Your ref:	W2 3TT/73	Please reply to:	Fraser Fikrie
Our ref:	21/05712/FULL	Tel No:	0753424 7967
		Fee Queries:	0207 641 6500;
		Email:	planningreception@westminster.gov.uk;
Clive Davis Clive Davis Architect 137 Harrowdene Gardens Teddington TW11 0DN UK		Incomplete Applications Development Planning City of Westminster PO Box 732 Redhill, RH1 9FL	
		25 August 2021

Address: 73 Porchester Terrace, London, W2 3TT

Proposal: Blocking of a window to ground floor rear elevation and introduce new window alongside back door; and increase size of lightwell in front garden.

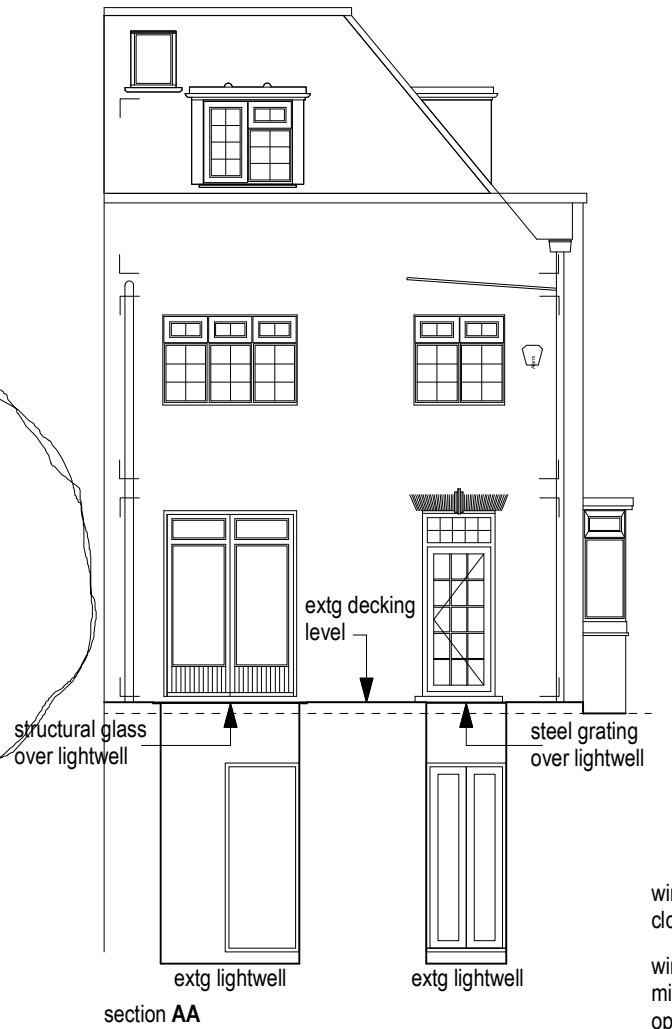
- Existing and proposed section through lightwell. Are railings proposed? if so existing and proposed elevations required.
- Annotated photographs of the areas of alteration.
- Existing plan should show existing lightwell and proposed show the proposed. Currently they both show both existing and proposed.
